FROM: Katie Kurek

TO: Arun District Council
FAO: A Gardner

SUBJECT: M/75/17/PL - 1 No. pair semi-detached chalet bungalows (alternative scheme to M/15/17/PL).

155, Middleton Road, Middleton on Sea, PO22 6DF

*proposed block plan*

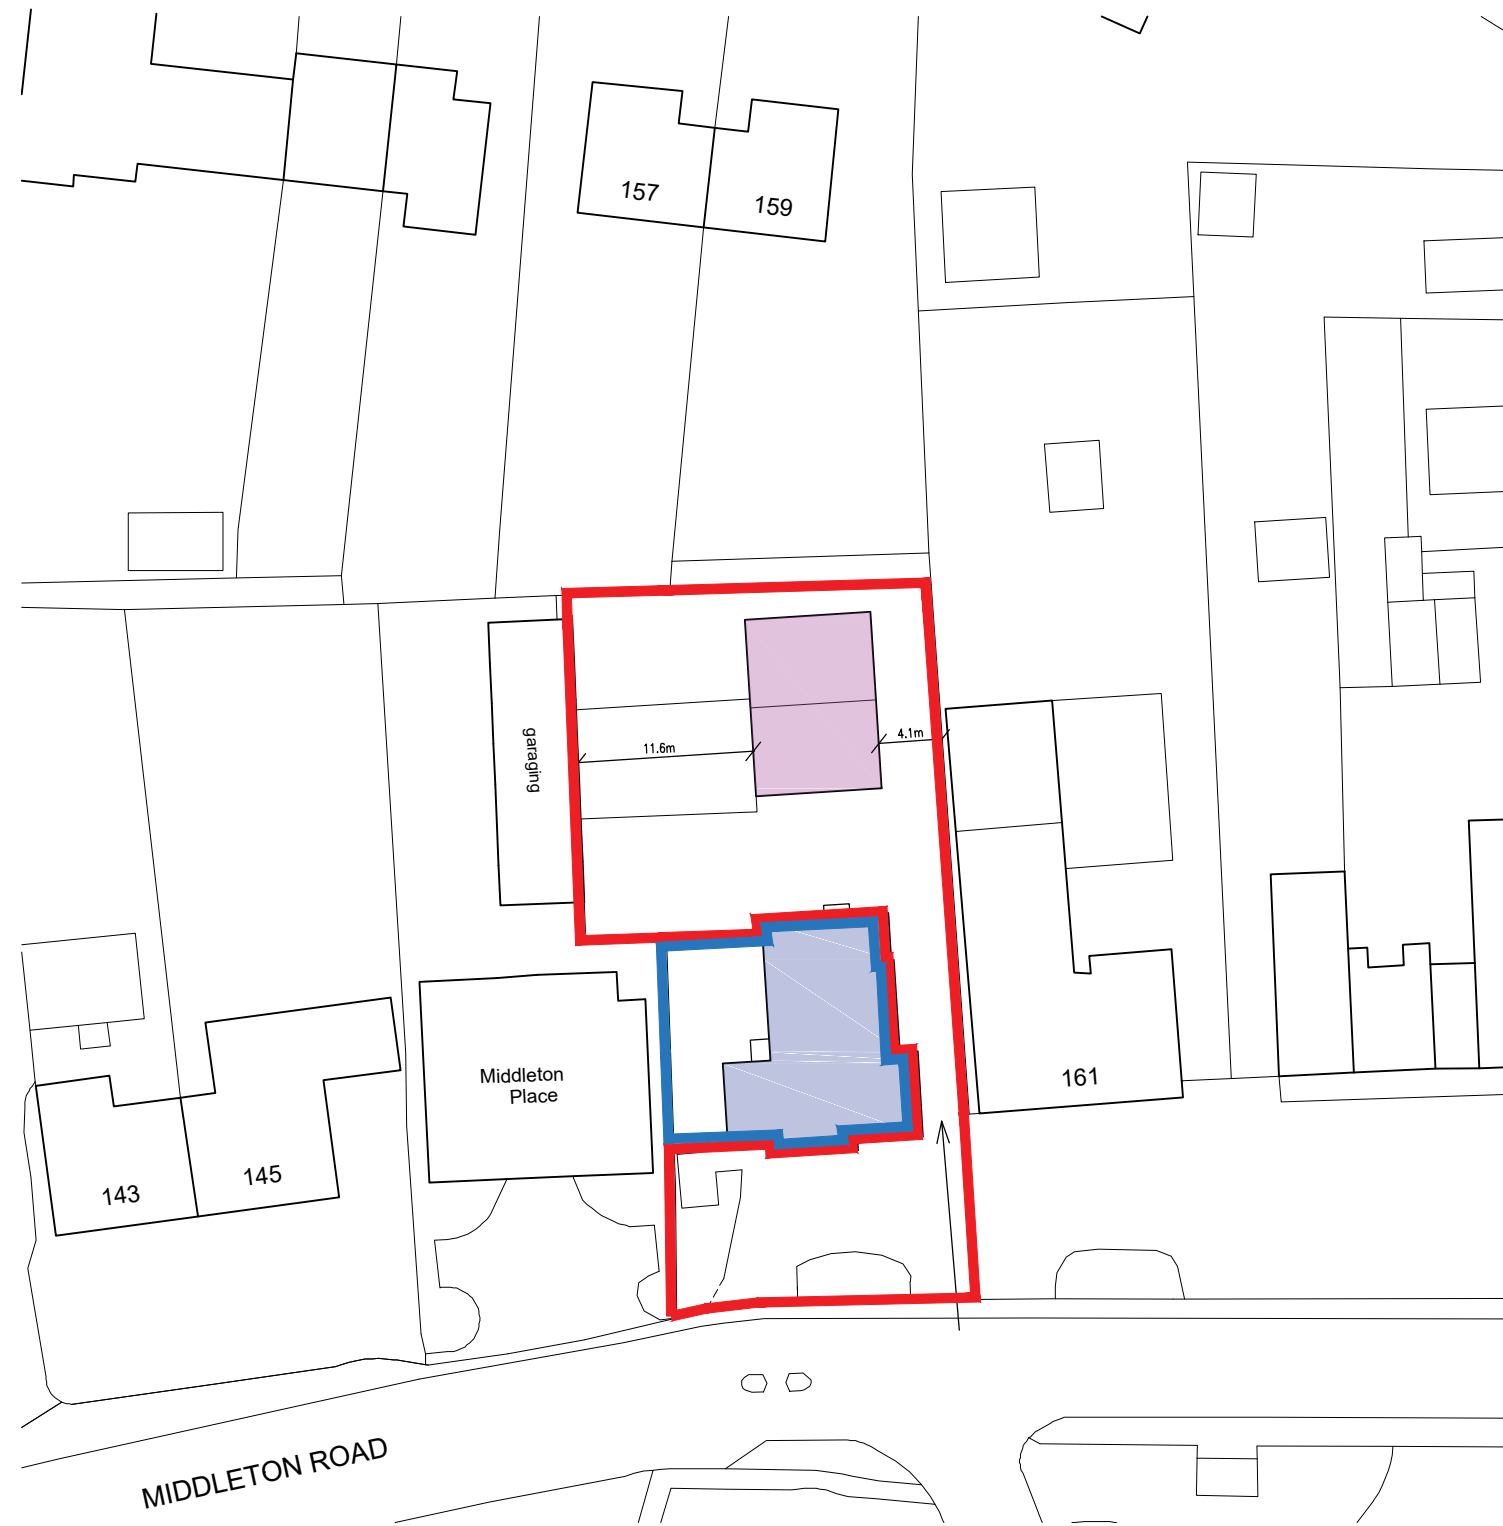
The existing access and parking arrangements will be retained as previously approved. The scale and footprint of the property is identical but will become 2 x 2-bedroom chalet bungalows. One allocated car parking space is provided per dwelling and two unallocated. On the basis of a single space being provided per dwelling the WSCC Car Parking Demand Calculator envisions a total demand for three spaces. A visitor and additional unallocated space will be provided also. The LHA are therefore satisfied with the proposed parking arrangements.

As previously commented manoeuvring from some of the car parking spaces appears restrictive and would require a multi-point manoeuvre. Whilst it would be beneficial for the applicant to demonstrate via swept path plans the workability of these arrangements, the LHA do not raise a highway safety concern.

With the possibility of two bungalows and two flats generating traffic movements and the access drive not being wide enough to allow two cars to pass, the LHA appreciate that a chance of conflict may occur requiring a vehicle to wait or reverse. Nevertheless there does appear to be space within the site to accommodate this without a reverse on to the public highway. On balance the LHA could not substantiate a highway capacity grounds to resist the application.

Refuse collection will be from the roadside and be collected from the bin store point along the driveway. The applicant has not clarified how a fire appliance will serve the site and may be required to clarify these arrangements to meet building regulations; however this is not a planning matter.

If the LPA are minded to approve the application the following conditions should be secured:

Car parking space (details approved)

No part of the development shall be first occupied until the car parking has been constructed in accordance with the approved site plan. These spaces shall thereafter be retained at all times for their designated purpose.
